Re: ESC Plan for Carlisle Blvd. & Menaul Blvd. Commercial Development Subdivision, 3535
Menaul Blvd NE - H16E083F - NMR1007QA - (SWQ-2026-00012)

E2RC thanks you for your correspondence and comments regarding the Carlisle Blvd. & Menaul Blvd. Commercial Development Subdivision project. This letter responds to each comment in your letter.

8

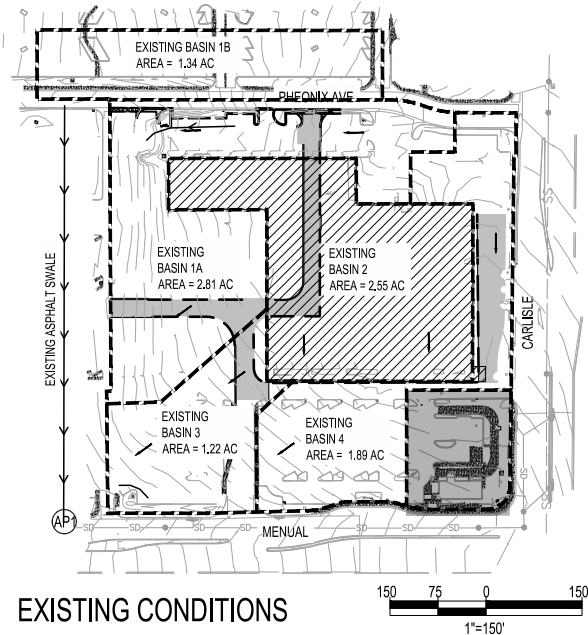
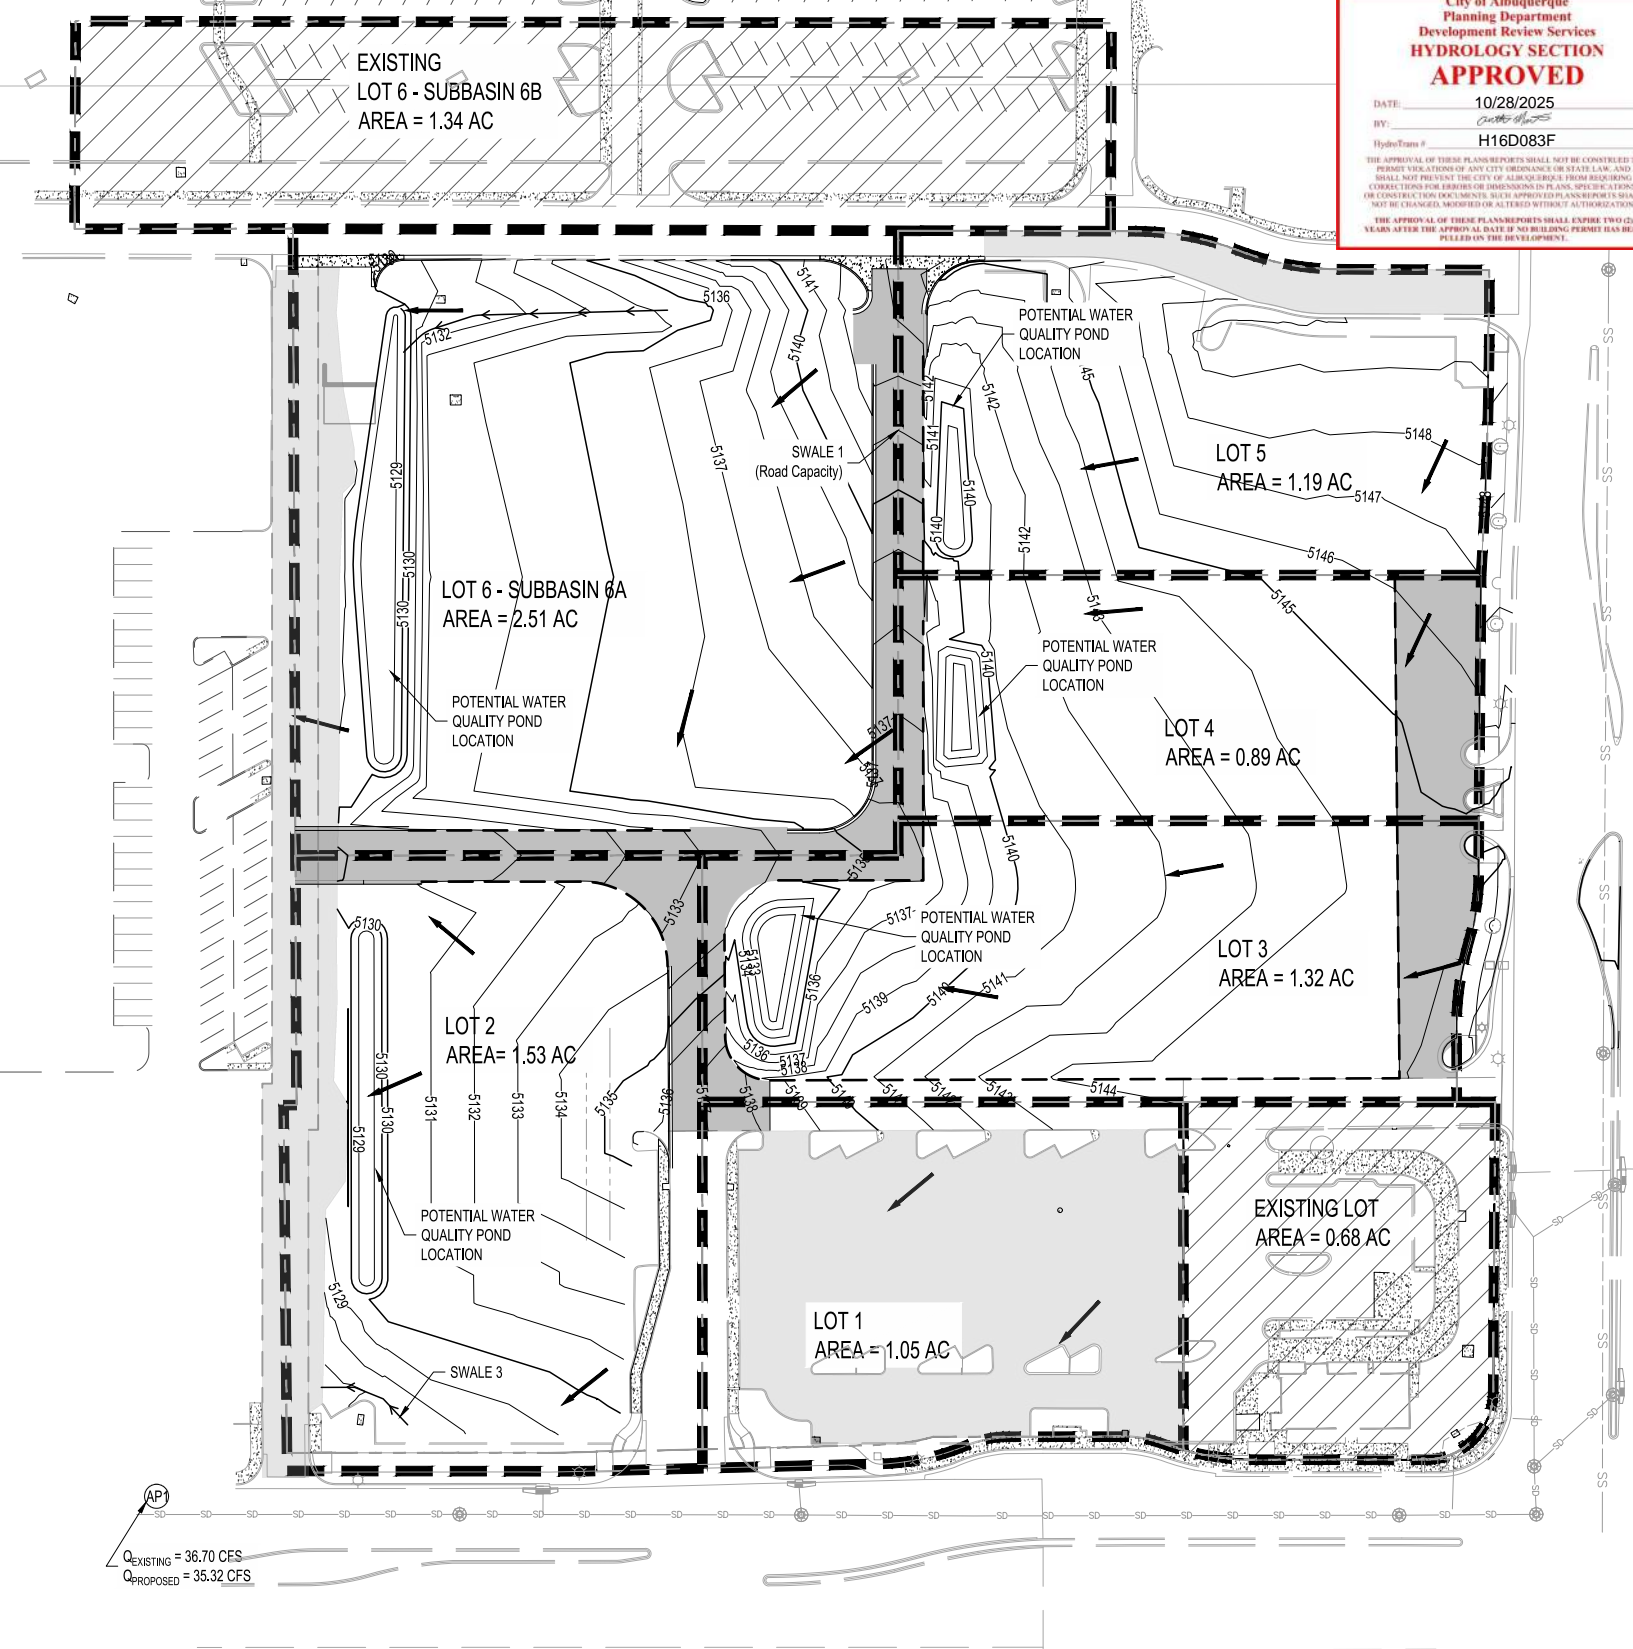
6. The label on Sheet 9 specifies the TESCP is for Phase II. We added a diversion swale on the south side of lots 2-B-3 and 2-B-2 to prevent drainage into the streets on Sheets 9 and 10. Diversion channels to prevent cross-lot drainage should be executed by the prospective buyers' prior to construction as part of the individual lot ESC plans. The *Temporary Diversion Channel* detail drafted by COA is still 'draft' and open to both comment and change. The earthen swale installation detail which was approved by COA Hydrology as part of the *Overall Grading Plan* is included on Page 9.
